DECISION DELEGATED TO HEAD OF PLANNING

Application No: H07-0311-24 **Applicant:** Mr A Zdroba

Proposal: Details of landscaping, foul water disposal and soakaway system for disposal of surface water (Conditions 3, 11 and 12 of H07-0815-20)

Location: 32 Hillgate Gedney Hill Spalding

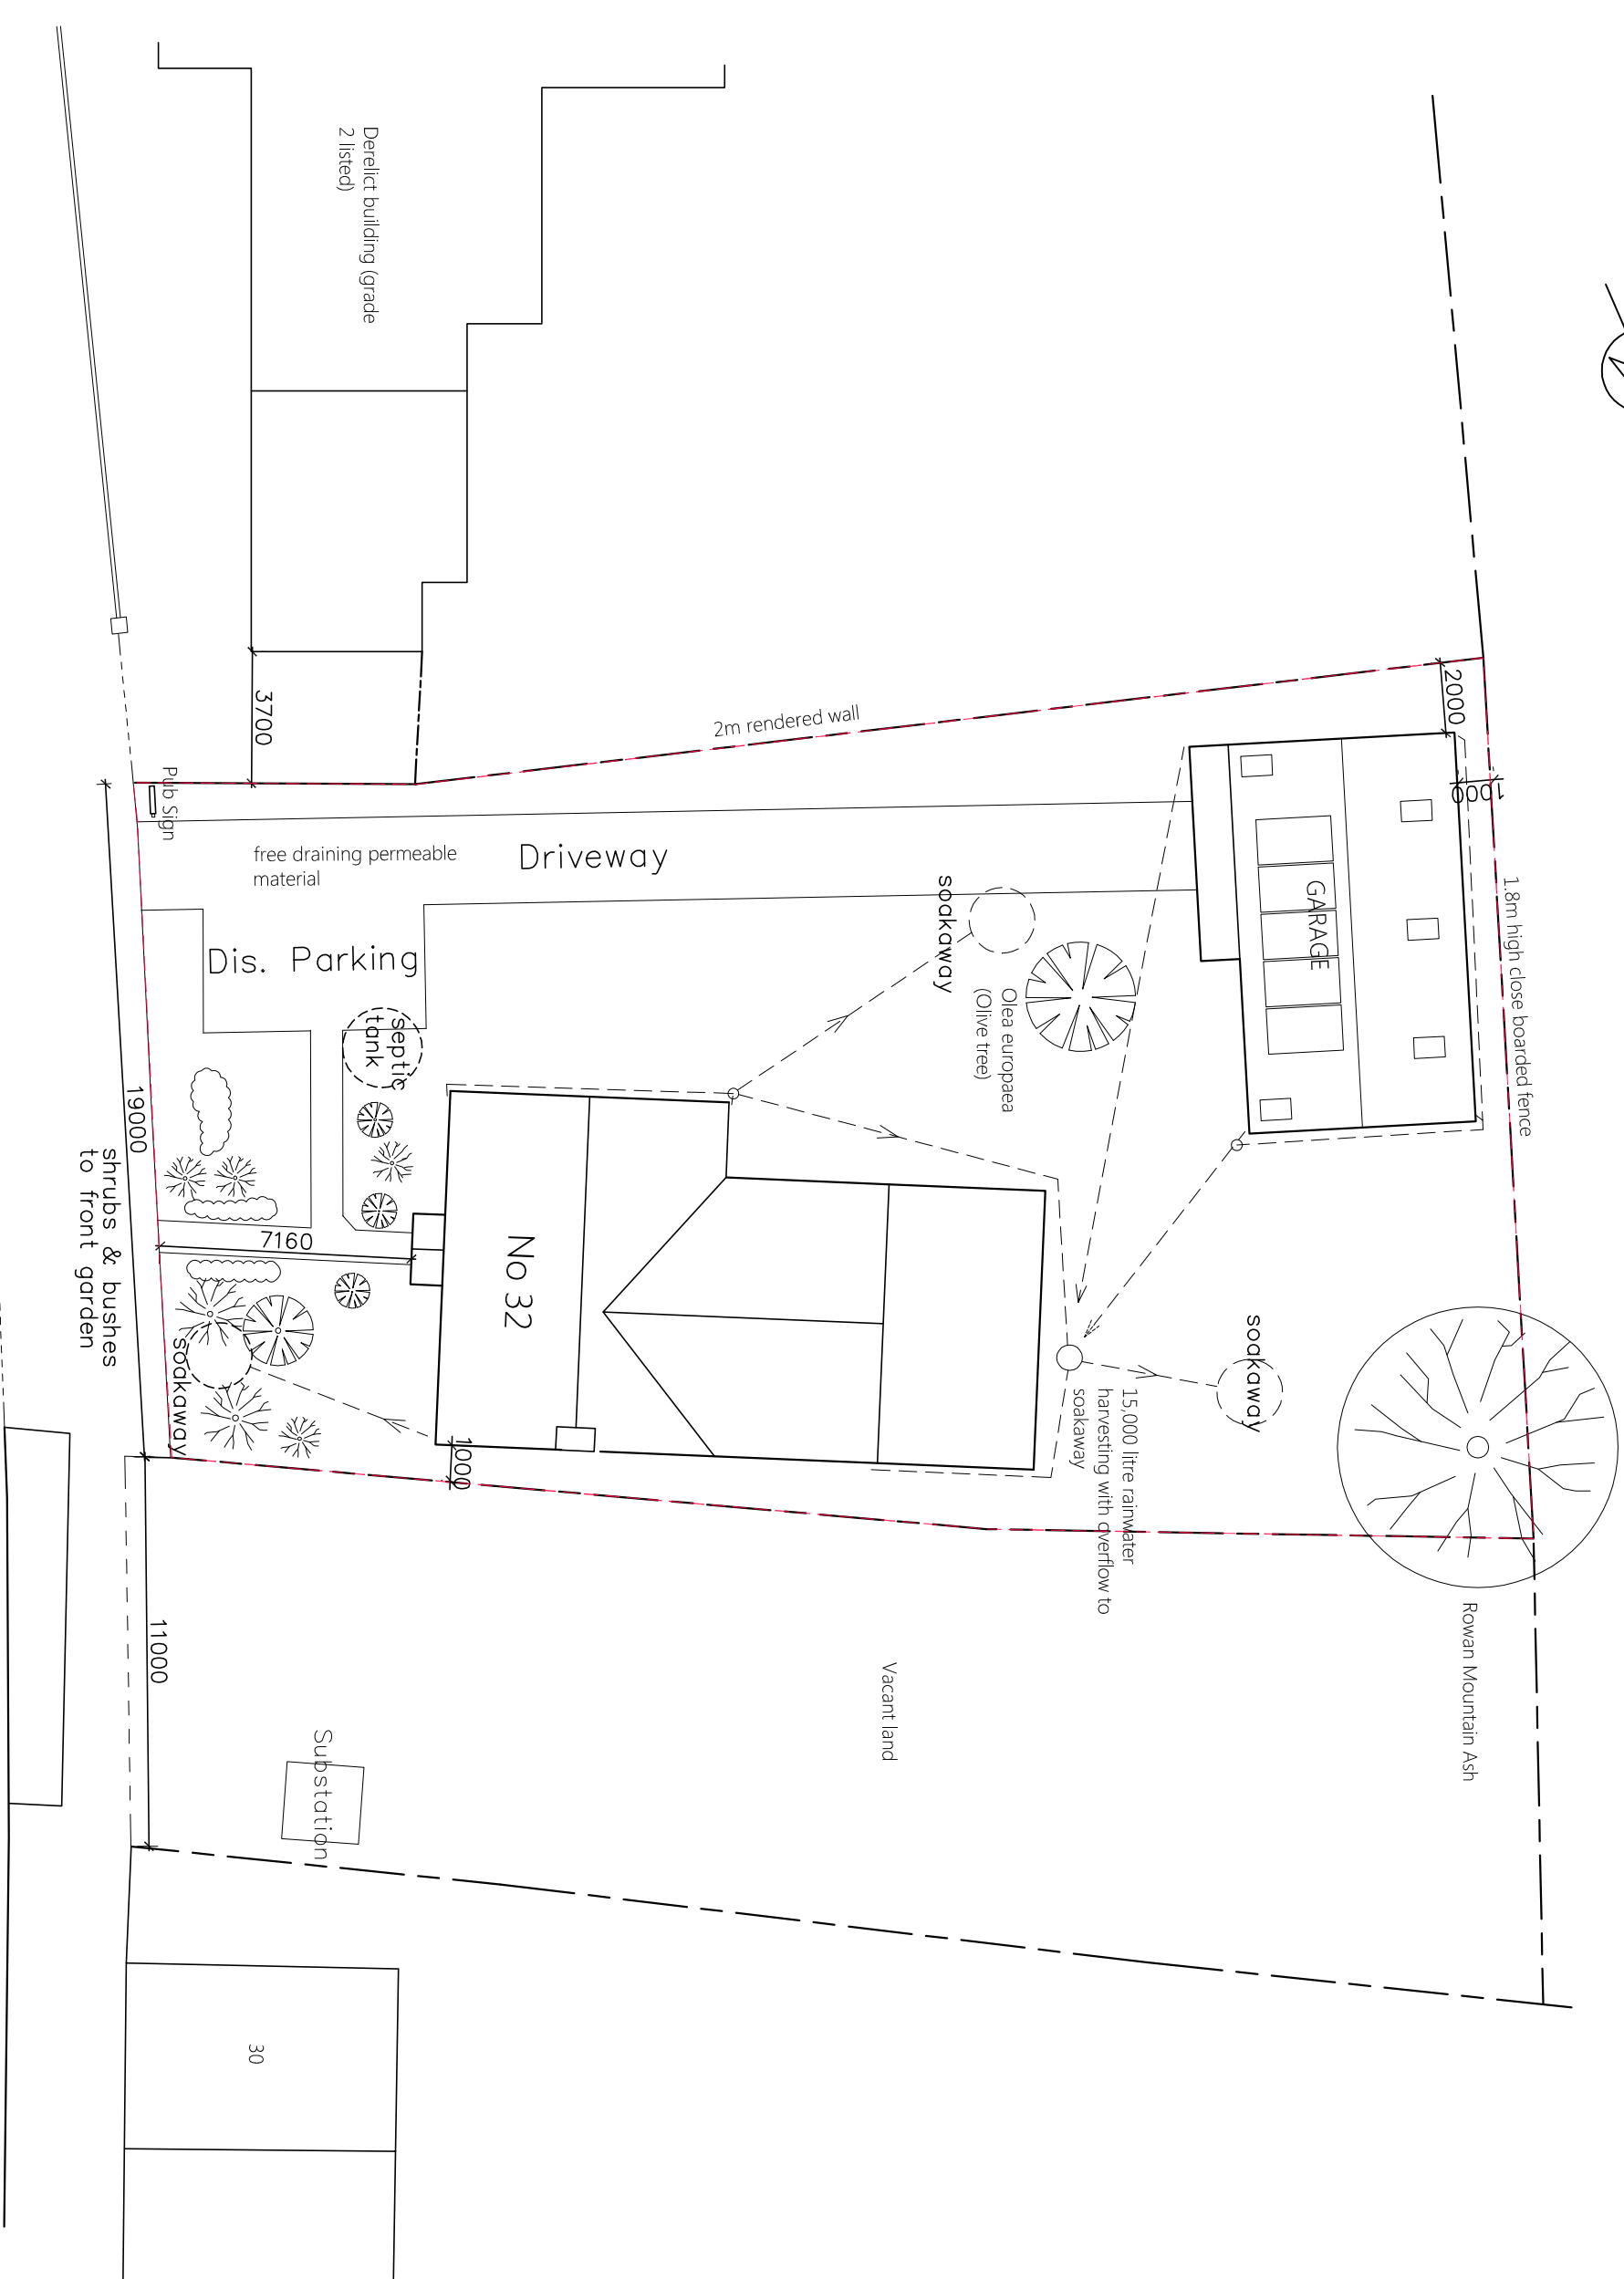
Condition 11 (Foul drainage) - The applicant has indicated that foul water would be disposed of to a Marsh Enco 12 people treatment plant, with an outlet of treated water to a 4000L soakaway. However, SHDC Building Control have stated that the outlet should either be to a drainage ditch (as per the application to SHIDB) or to a drainage field (not a soakaway). If the site has been excavated and replaced with hardcore a drainage field would not work adequately.

Condition 12 (Full details of means of surface water disposal) - The submitted plan indicates that surface water from the front section of the house would be disposed of to a soakaway within the front garden. Surface water from the remainder of the house (and detached garage) would be disposed of via a 7,500 litre rainwater harvesting tank with an overflow to a well and water attenuation tank and thereafter an outfall to a riparian drain to the south-west over neighbouring land. Consent appears to have been obtained from the neighbouring land owner to the south to connect the outfall pipe to the riparian drain.

Note that the applicant's proposal includes a direct surface water discharge into a piped watercourse in addition to the use of a soakaway. We would typically recommend that the proposed discharge to a soakaway is supported by infiltration testing in line with BRE Digest 365 (or equivalent) to evidence whether the soakaways can work efficiently.

The rainwater soakaway to the front of the dwelling should be sized accordingly based on the results of a percolation test carried out in that area of the plot.

The attenuation tank should be kept a minimum 5 metres from any building and a minimum 2.5 metres from the boundary.

The outlet from the treatment plant should either be to the drainage ditch (as per application to SHIDB) or to a drainage field, not a soakaway. If the site has been excavated and replaced with hardcore, a drainage field will not work adequately.

In light of the above comments, it is considered that the information presently submitted does not satisfactorily demonstrate that the proposed foul and rainwater systems are viable without increasing flood risk on or adjacent to the site. Consequently, conditions 11 and 12 cannot presently be discharged.
